DEPARTMENT OF PLANNING, INDUSTRY AND ENVIRONMENT

Mayfield West Waste Facility Modification 1 – SSD-7698-Mod-1 – additional information required

The EPA has reviewed the *Mayfield West Recycling Facility – SSD 7698 – Proposed Modification – Section 4.55(1a) application* report prepared for Benedict (the Modification Report) and provides the following comments:

Figure 1. SSD 7698 Proposed Modification to the Development Layout Plan

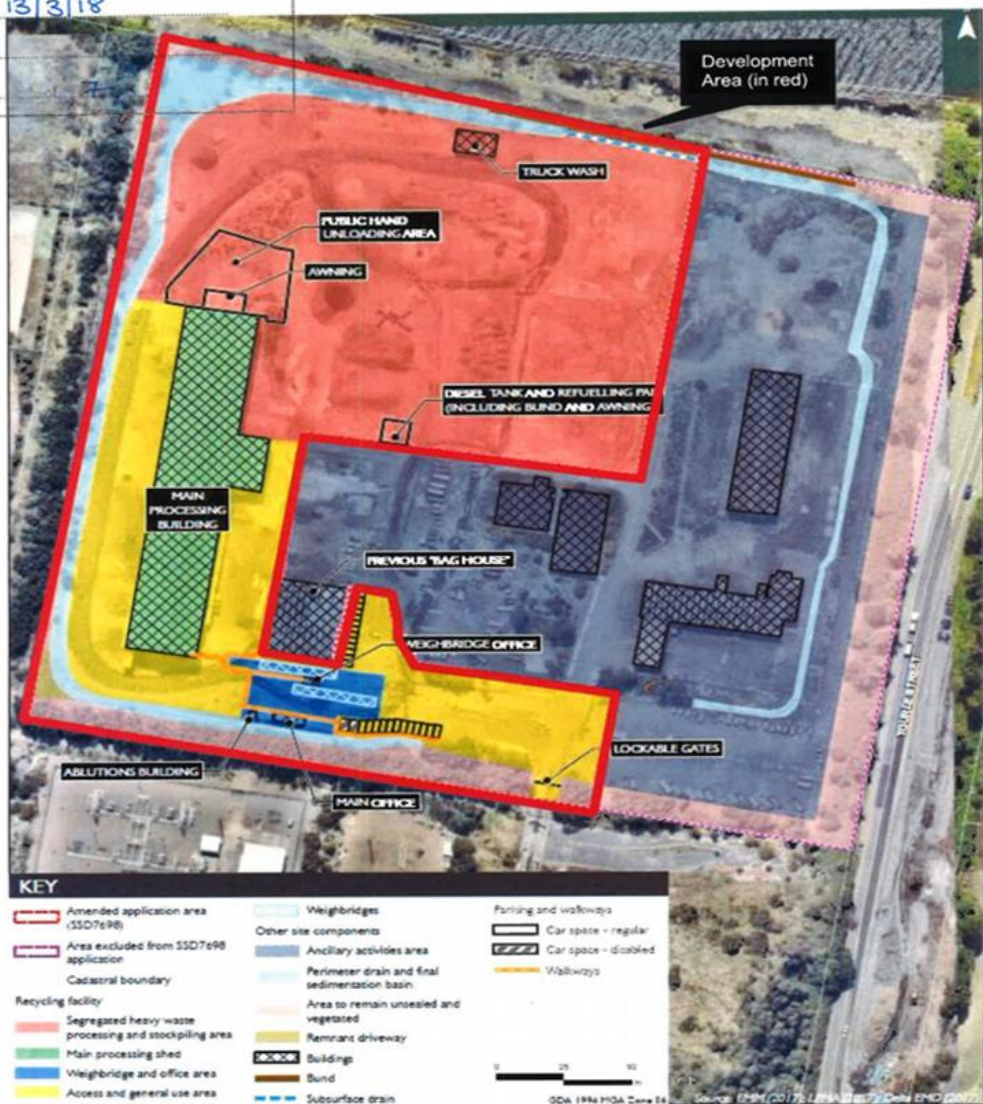
- It is unclear what material will be stored in the proposed heavy material storage area;
- It is unclear whether the proposed heavy material storage area will also be used for unloading and processing as well as stockpiling;
- It is unclear what the potential dust impacts will be from the proposed heavy material storage area; and
- It is unclear whether Benedict intend to remove the approved recycling facility covered by DA2015/0291 to avoid conflicts between the two consents as required by paragraph A30 of SSD-7698.

- Describes the type/types of material proposed to be stored in the new heavy material storage area;
- Describes the activities proposed to be undertaken in the new heavy material storage area, including the proposed traffic access routes and estimated vehicle frequency using the area; and
- Assesses potential dust impacts resulting from the storage of materials in the new heavy material storage area, including the identification of appropriate mitigation measures where required.
